9 July 2015

File Number: 2015/342070
Our Ref: R/2015/25

**RE: MP 09_0007 MOD 2 – Stage 1 Project Application – Library Building,
Moore Theological College, 1-11 King Street, Newtown**

Drawing Title
SECTIONS

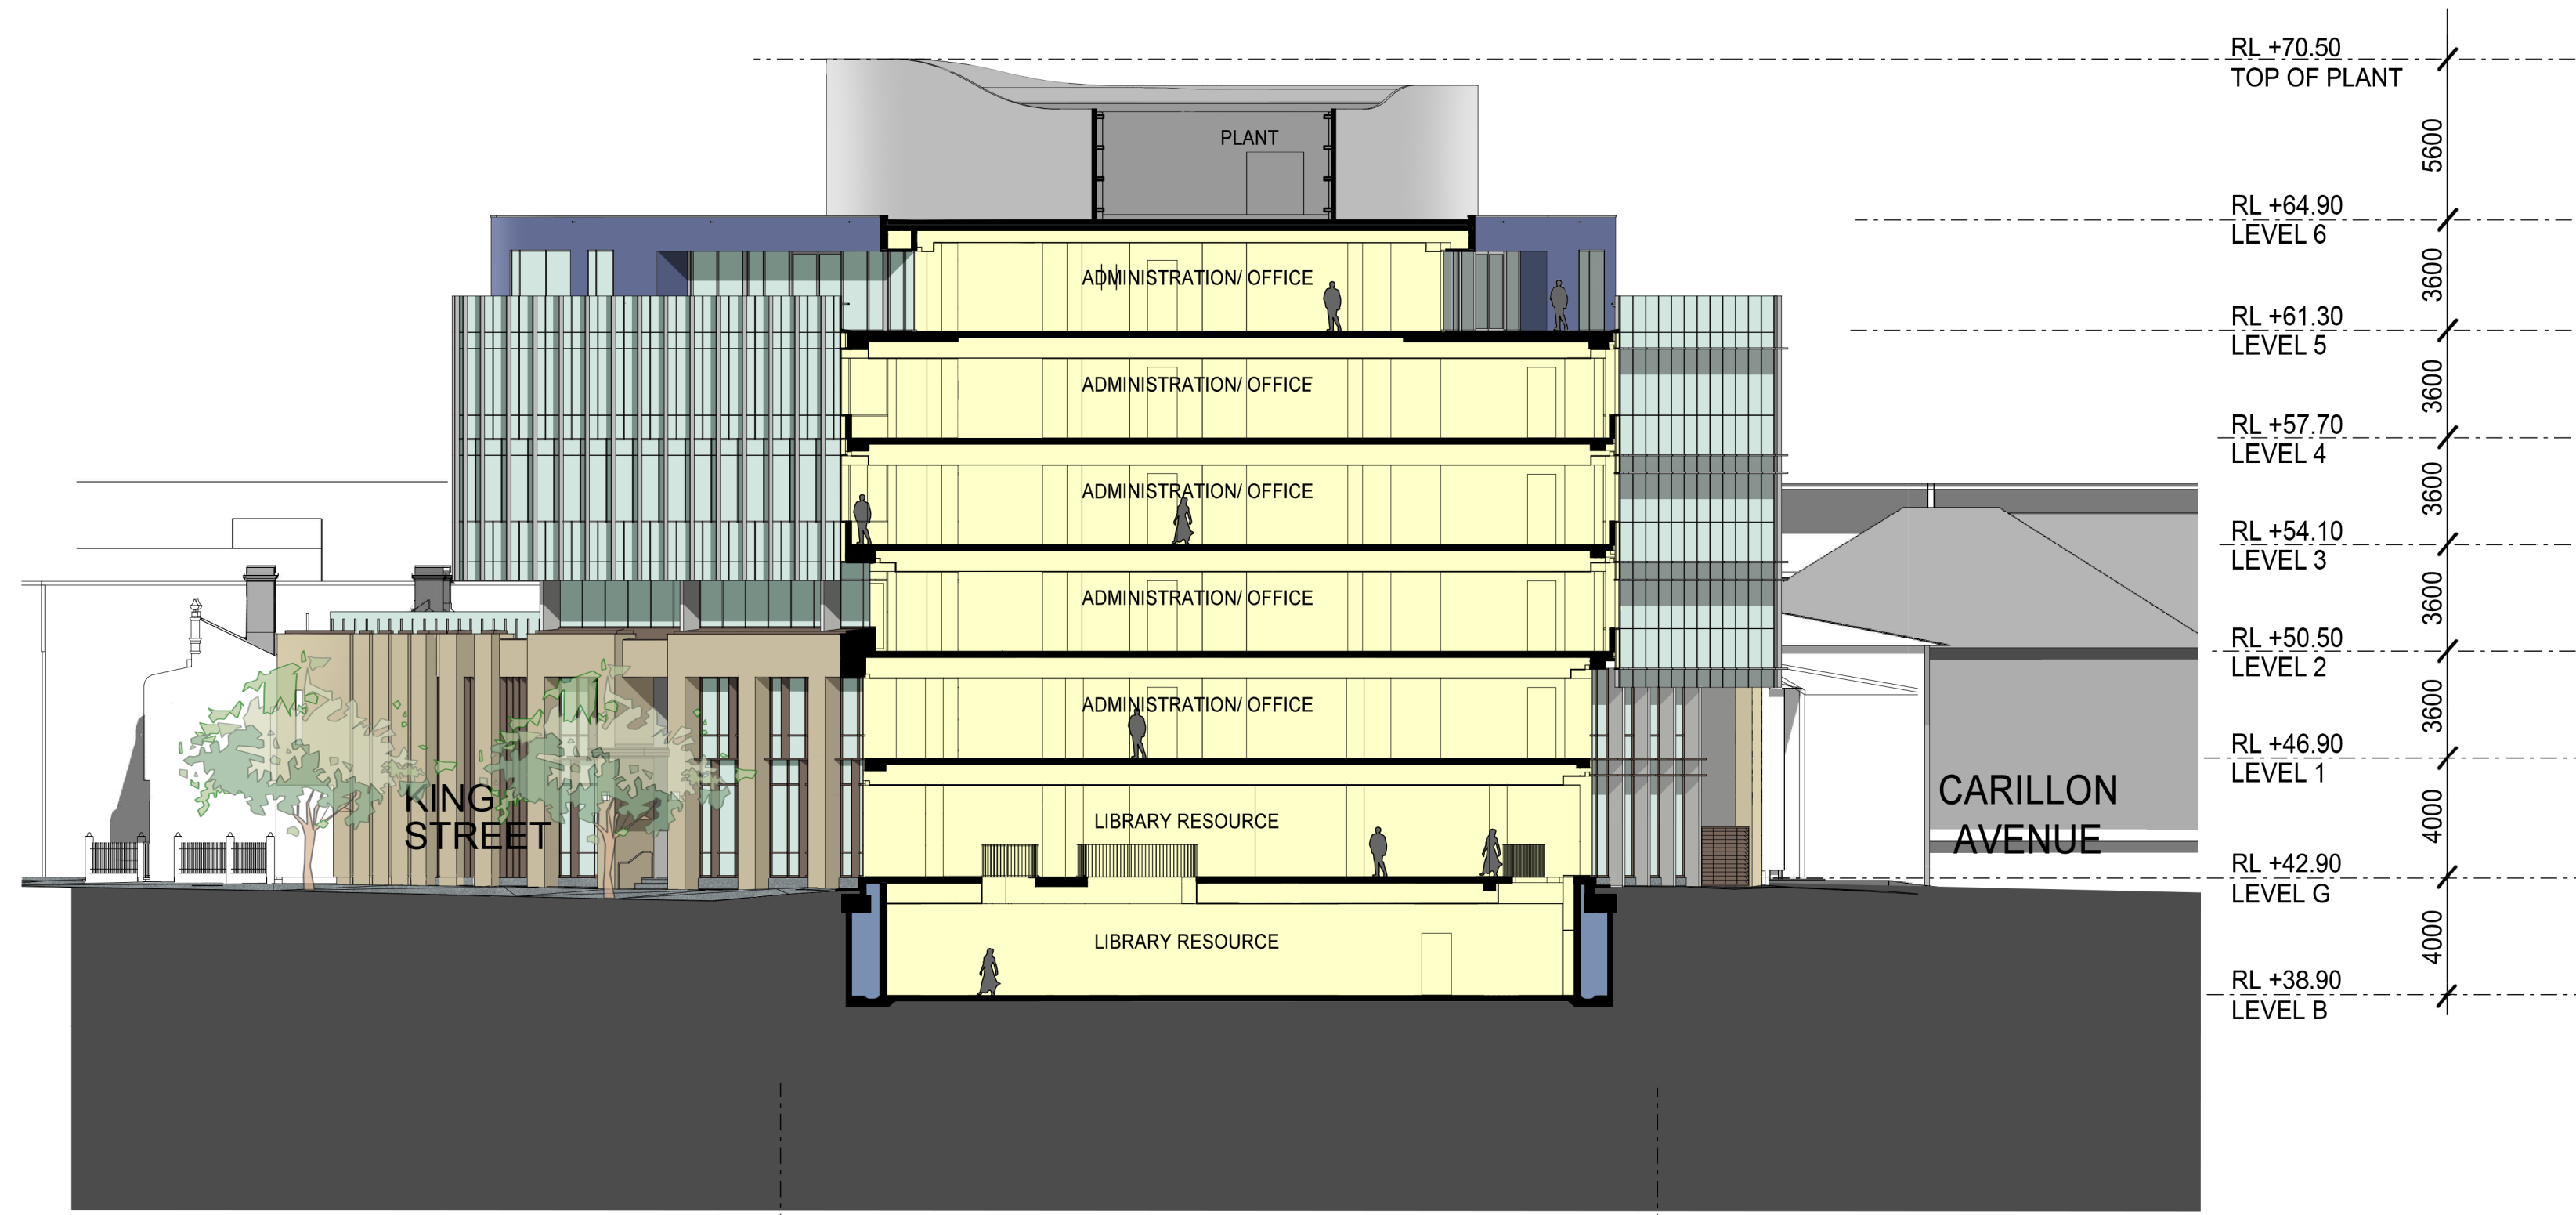
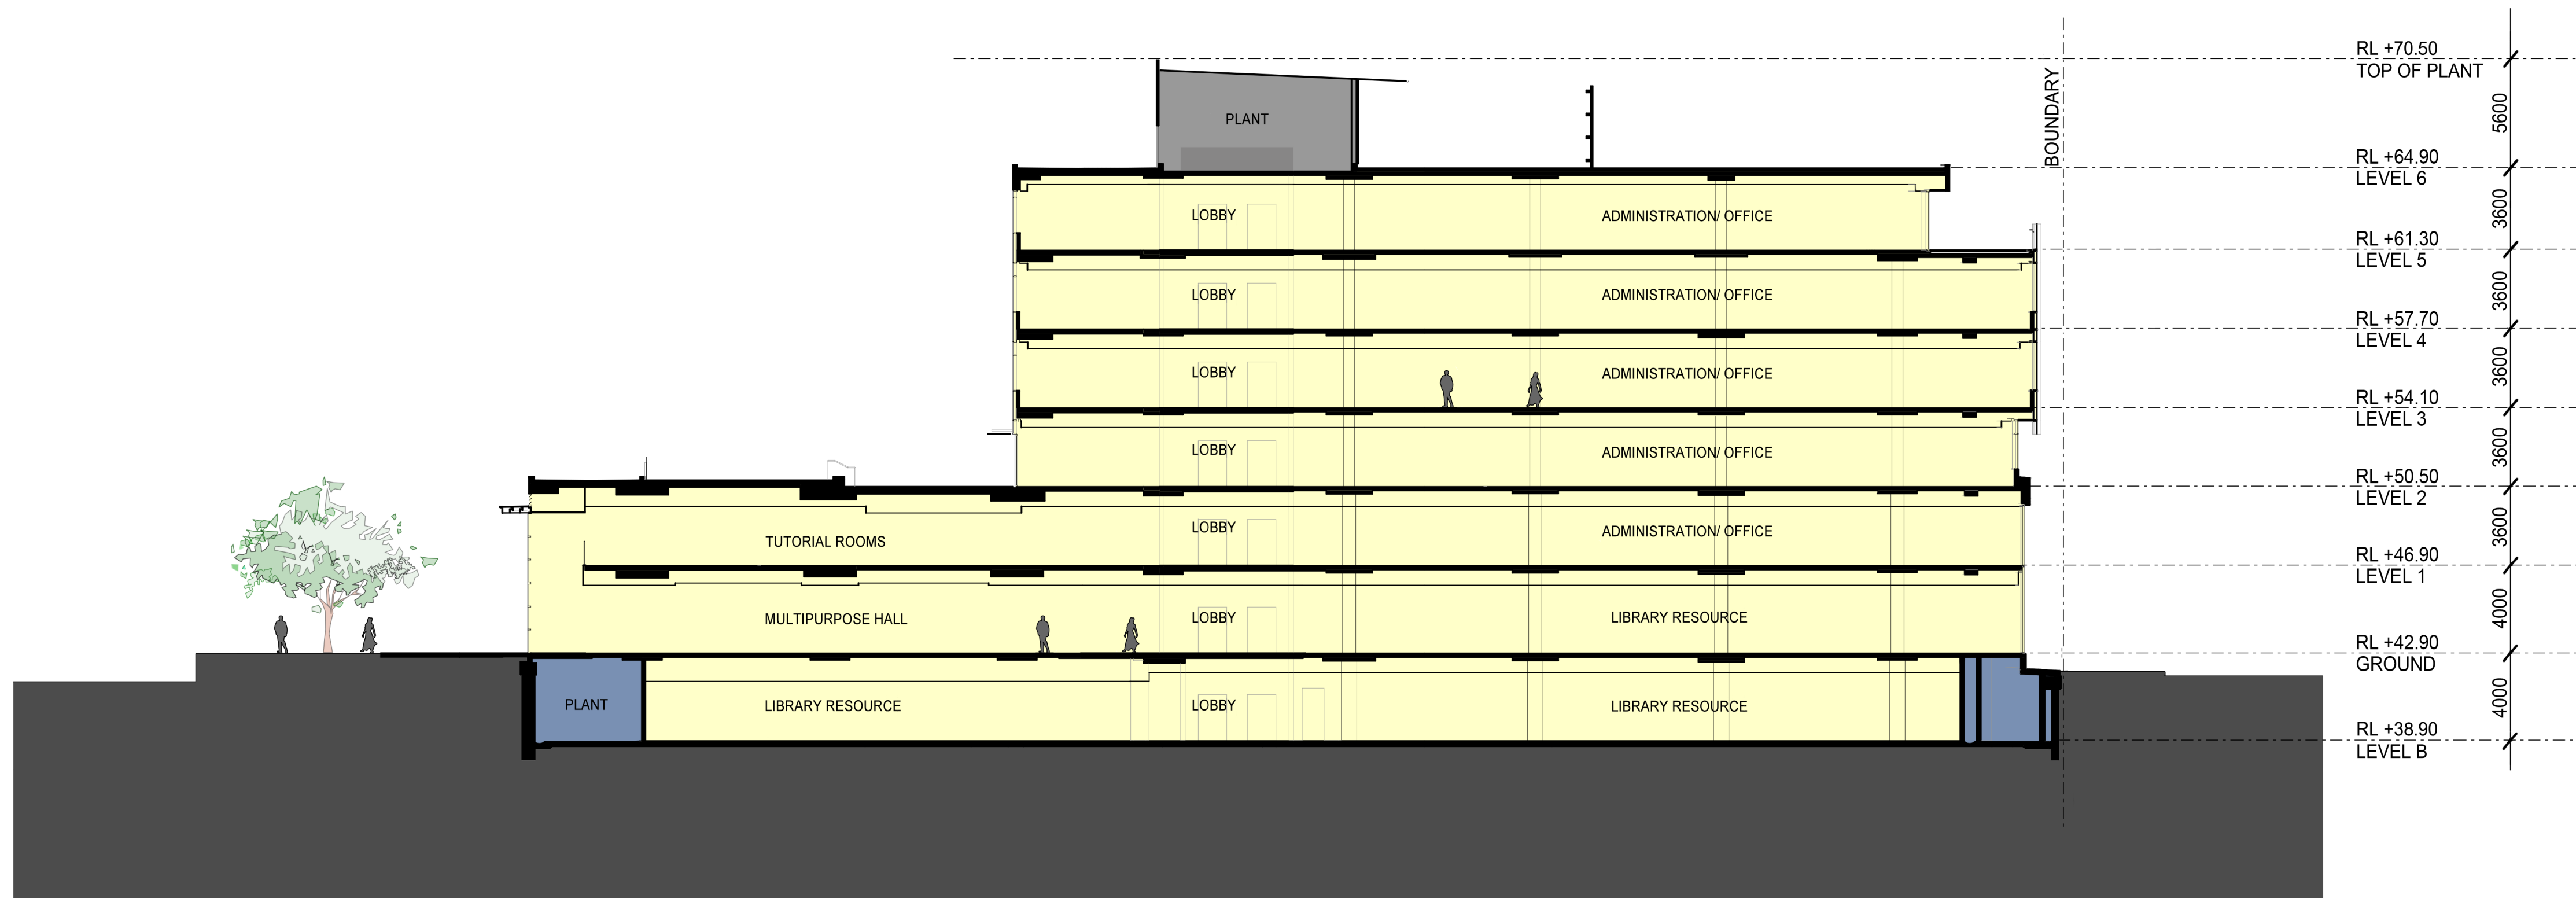
The elevations illustrate the currently approved building envelope in relation to the proposed modification. It appears that the overall roof height may have been reduced; however the City is not able to verify this as the currently approved plans do not include RLs on the upper level plans or the elevations. The applicant should confirm amendments to the proposed floor levels are proposed. If the floor to ceiling heights are proposed to be amended, the Department should satisfy itself that the new clearances are appropriate for the intended uses.

Drawing Title
ELEVATIONS

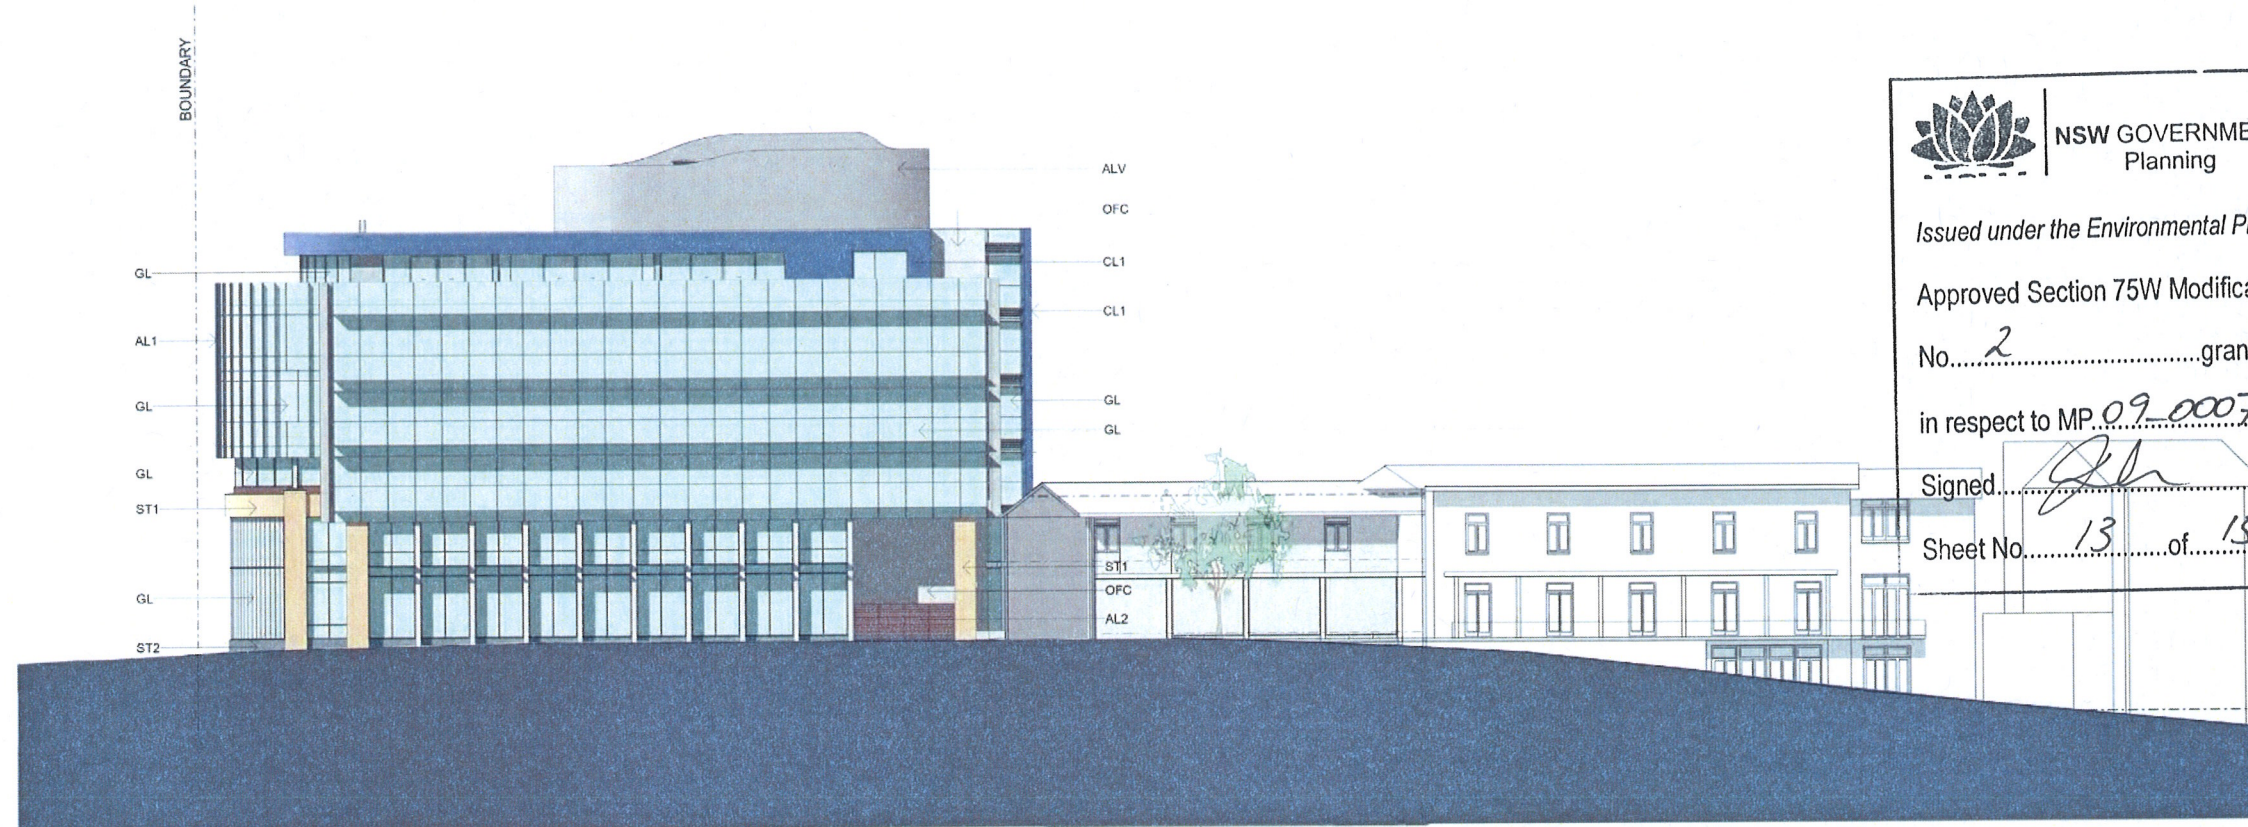
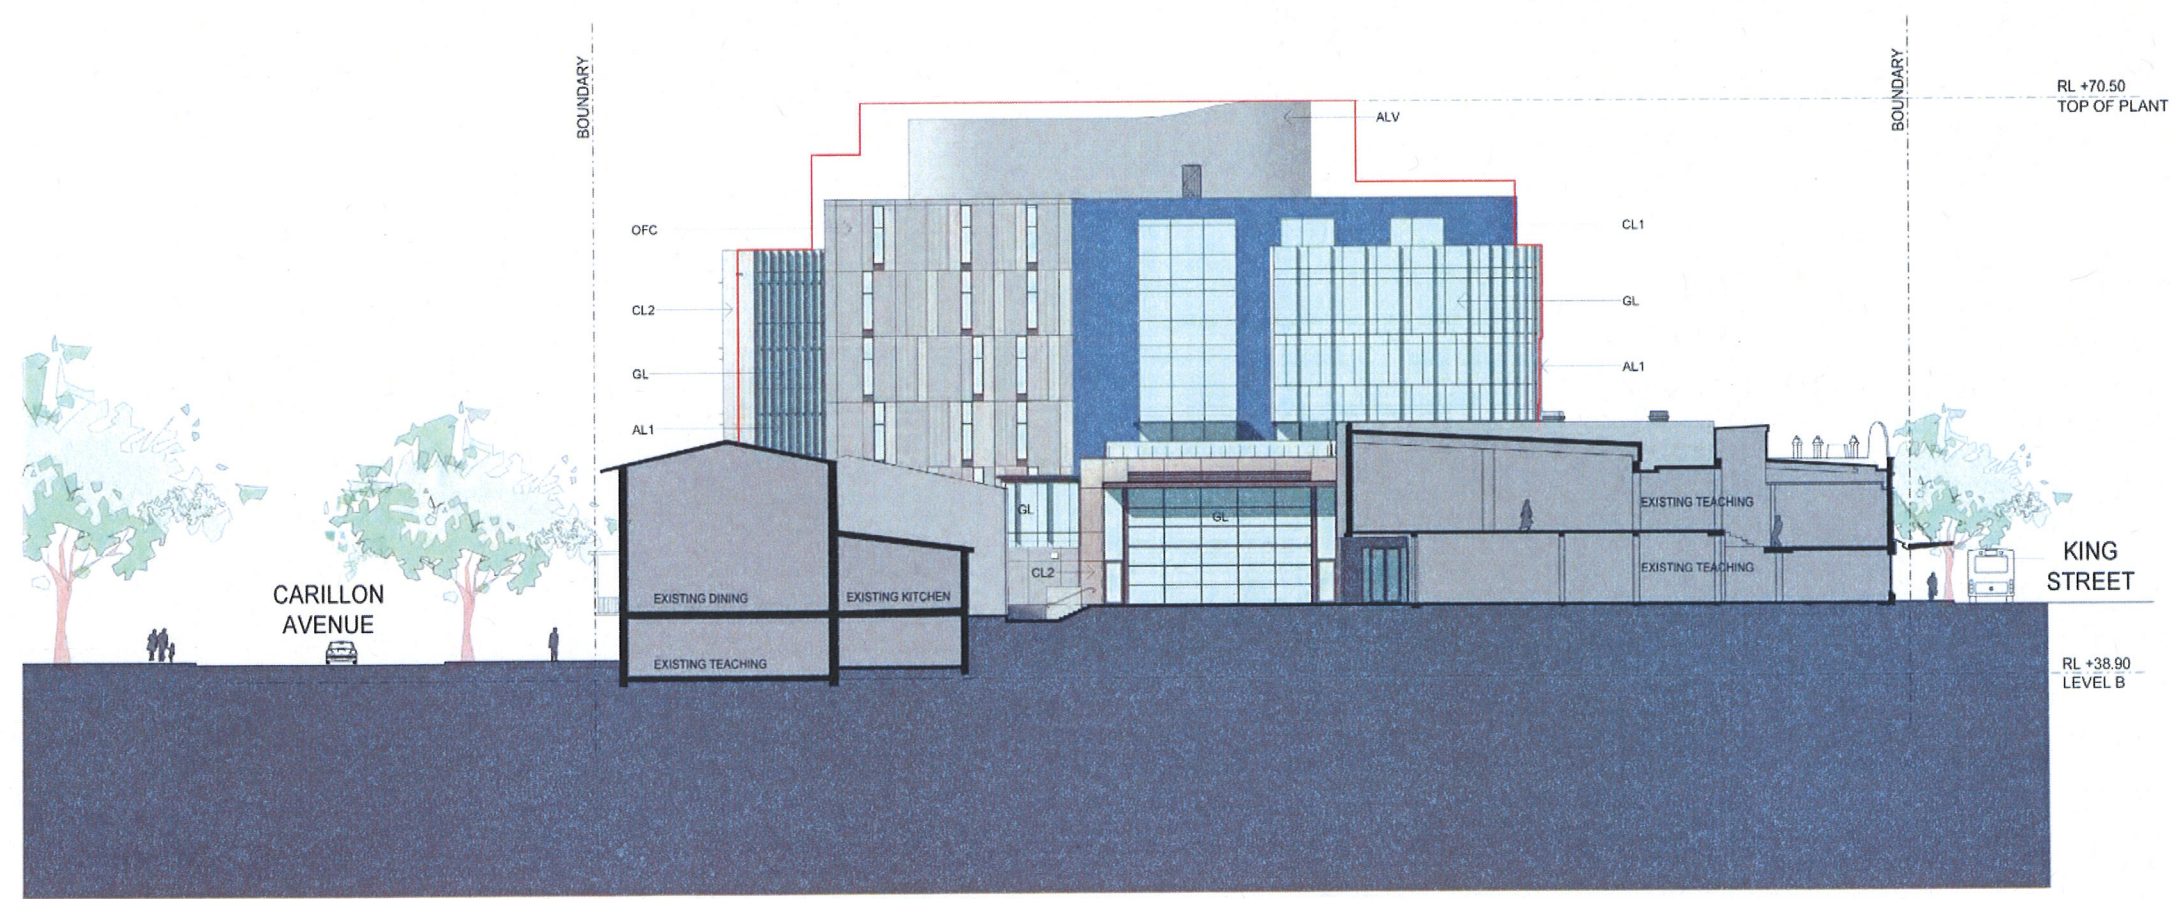
No objection is raised in principle to the proposed facade blades on the Carillon Avenue frontage, however it is noted that they are potential signage zones. The

applicant should advise if the intention is to install signage in these locations and amend the application if necessary.
